Recommendation Report for Planning Permission for Works or Extension to a Dwelling

REF NO: R/116/21/HH

LOCATION: 17 Mill Close
Rustington
BN16 3HR

PROPOSAL: Erection of single storey rear extension

Plans & Elevations As Proposed

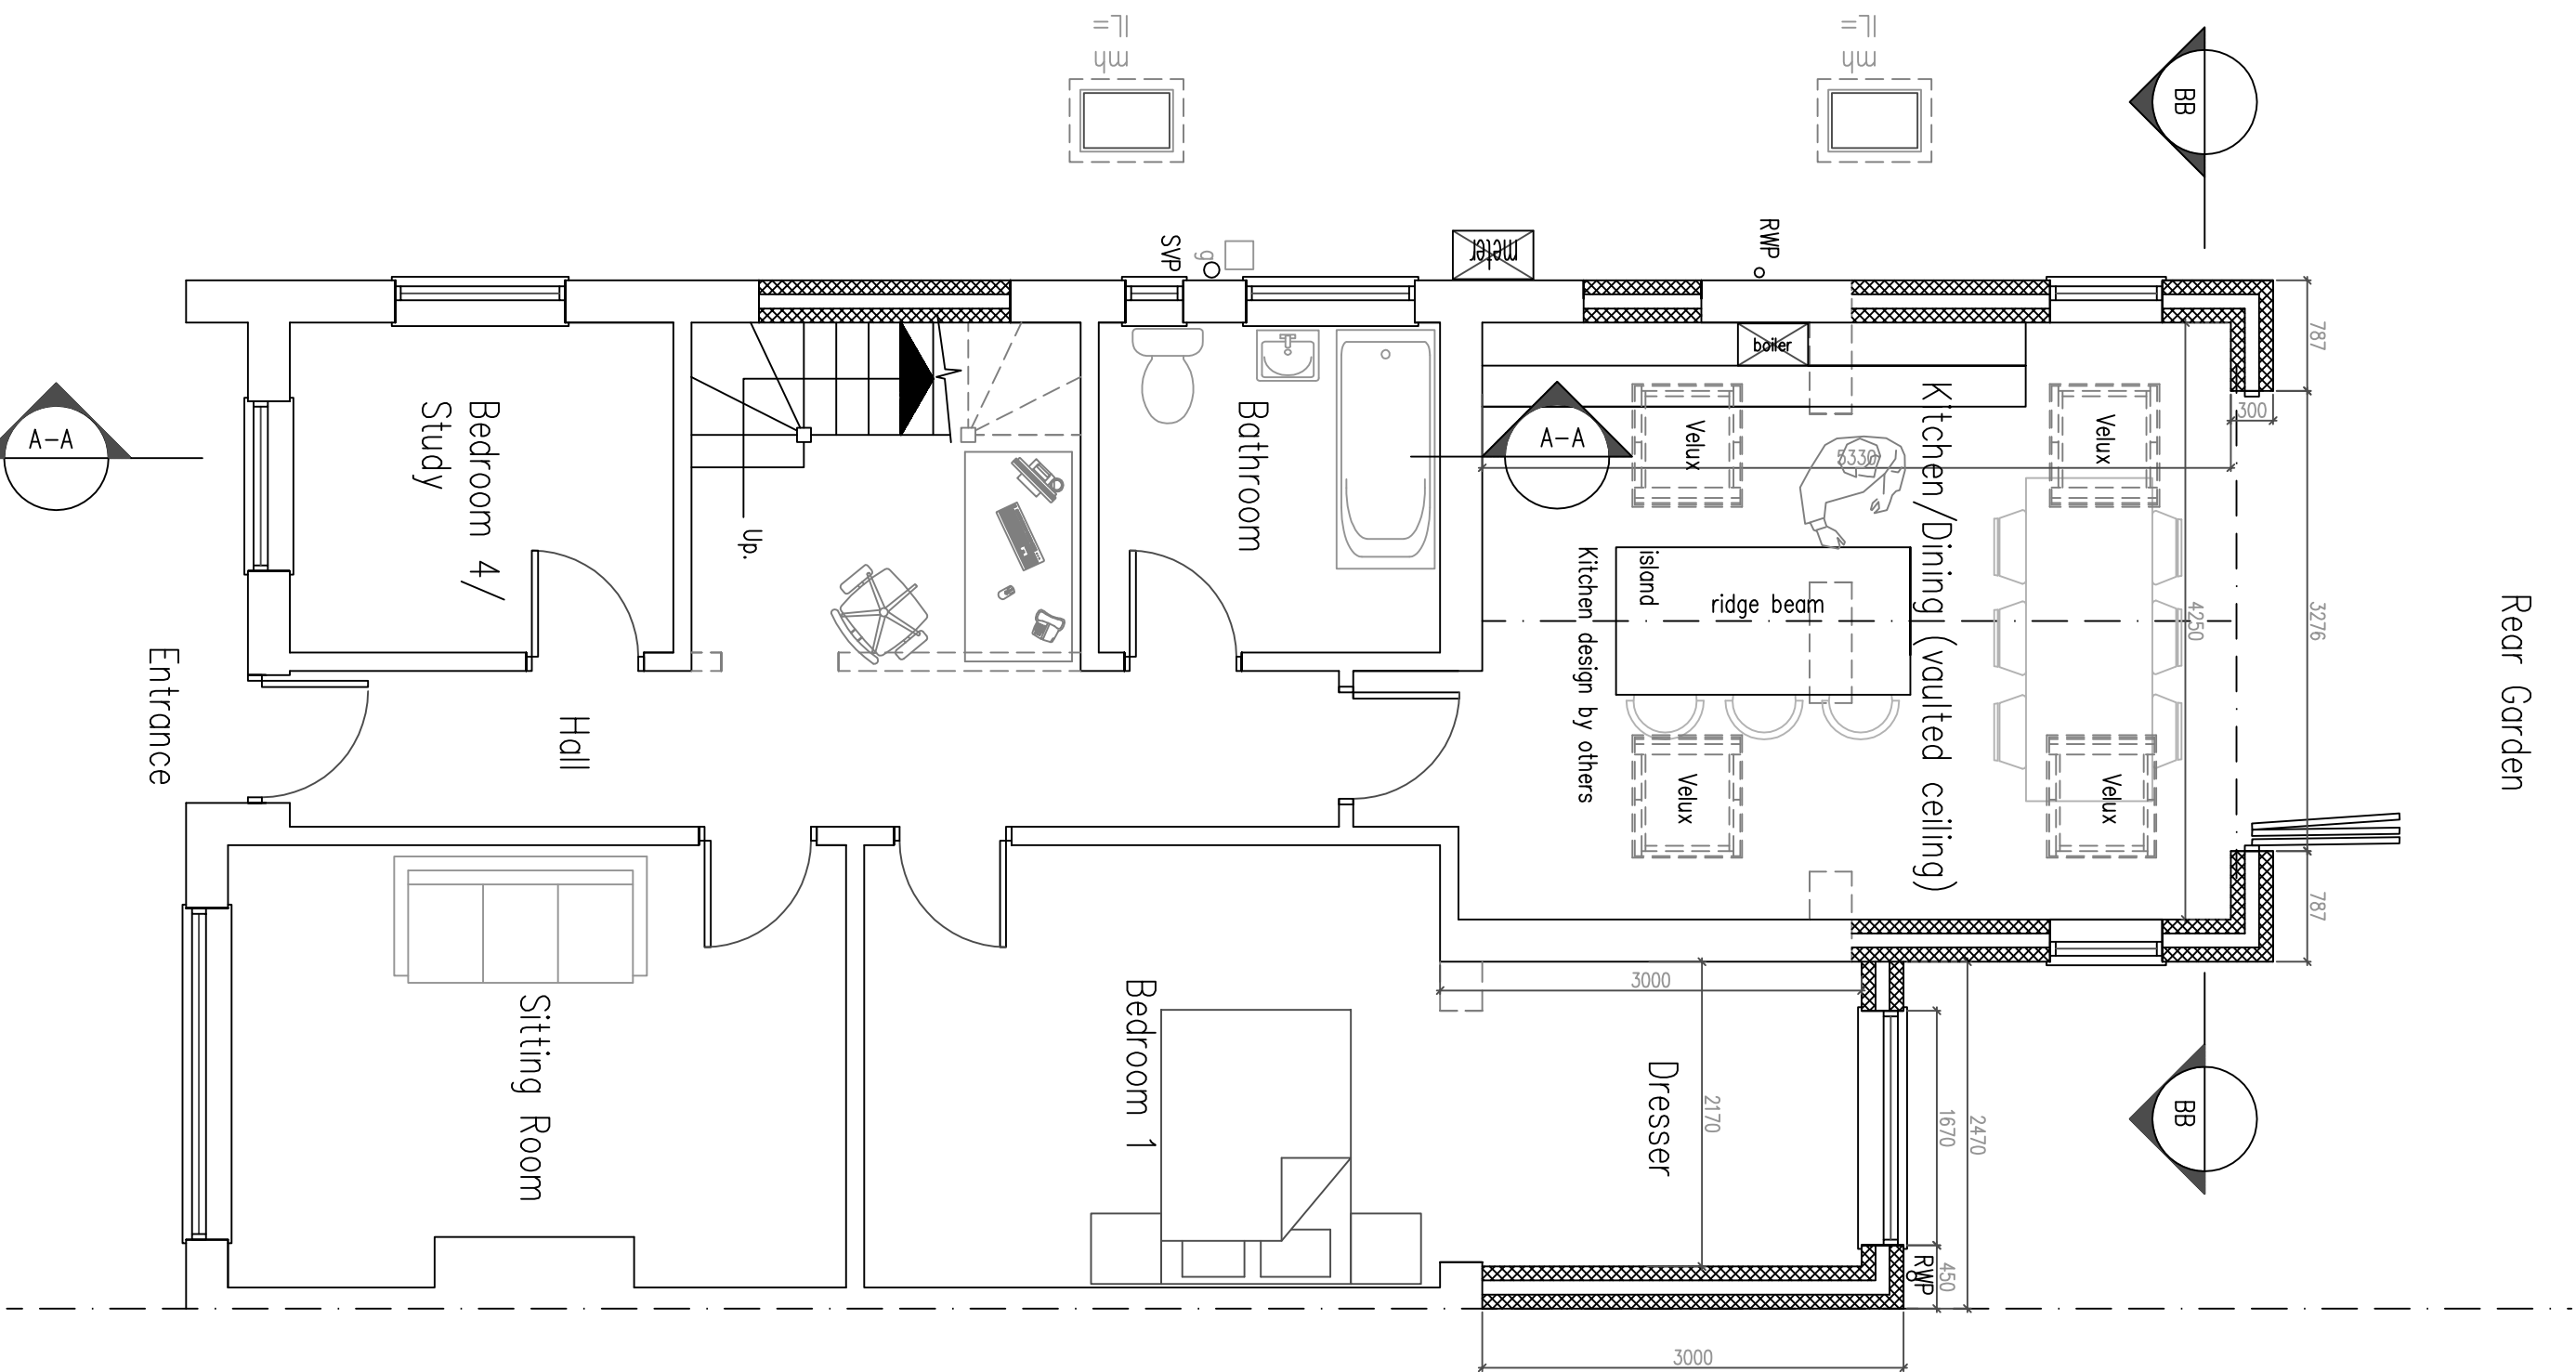
The single storey rear (east) extension has a pitched roof which continues at same height as existing single storey extension eaves so the roof design visually integrates with existing property so complies with policy D DM1 of the Arun Local Plan.

The proposed single storey rear (east) extension will have a width of approximately 4.86m and a depth of approximately 3.02m. The height to pitched roof will be approximately 4.14m.

There will be new bi-fold doors on east elevation facing garden to rear (east), two new floor to ceiling windows on north and south elevations of extension and two new roof lights in north and south roof elevations.

The proposed rear (south east) corner part infill extension flat roof design whilst not in-keeping with

existing property, it is at single storey and is subservient to main dwelling so is acceptable.

The proposed rear (south east) corner part infill extension will have a width of approximately 2.46m and a depth of approximately 3.00m. The height to flat roof will be approximately 2.54m.

The proposal will have a triple windows (2 openable and 1 fixed) to rear (east) elevation of extension facing garden to rear.

The single storey rear (east) extension will have a width of approximately 4.86m and a depth of approximately 3.02m. The height to pitched roof will be approximately 4.14m. Due to siting at rear (east) of property there is increased risk to overshadowing or overbearing effect to neighbouring property number 16 to south however due to being at single storey and gap of 2.01m remaining to southern boundary there is no adverse harm to overshadowing/overbearing effects to the south so is acceptable.

Due to new bi-fold doors in east side elevation of extension there is increased risk to overlooking to neighbouring properties to east however due to gap of around 6.41m remaining to east side boundary and properties to east set back there is no adverse harm to overlooking to neighbouring properties to east.

Due to the new floor to ceiling window in north and south elevations of extension there is increased risk to overlooking to north however gap of around 8.67m remaining to north boundary and boundary fence to north there is no adverse harm to overlooking to north. Whilst the new window will increase risk of overlooking to south due to smaller gap of around 2.18m remaining to southern boundary, the proposal being at single storey and location of boundary fence to south reduces impact of overlooking to neighbouring properties to south so is acceptable.

The proposed rear (south east) corner part infill extension will have a width of approximately 2.46m and a depth of approximately 3.00m. The height to flat roof will be approximately 2.54m. Due to the siting at rear (south east) corner of dwelling there is increased risk to overshadowing or overbearing effects to neighbouring property number 16 to south however due to it being at single storey and the neighbouring property set back there is no adverse harm to overshadowing or overbearing effect to neighbouring property to south.

Due to new triple windows in rear (east) elevation of extension facing garden to rear there is increased risk to overlooking to neighbouring properties to east however due to gap of around 8.61m remaining to rear (east) boundary and boundary fence to east there is no adverse harm to overlooking to east so it is acceptable.
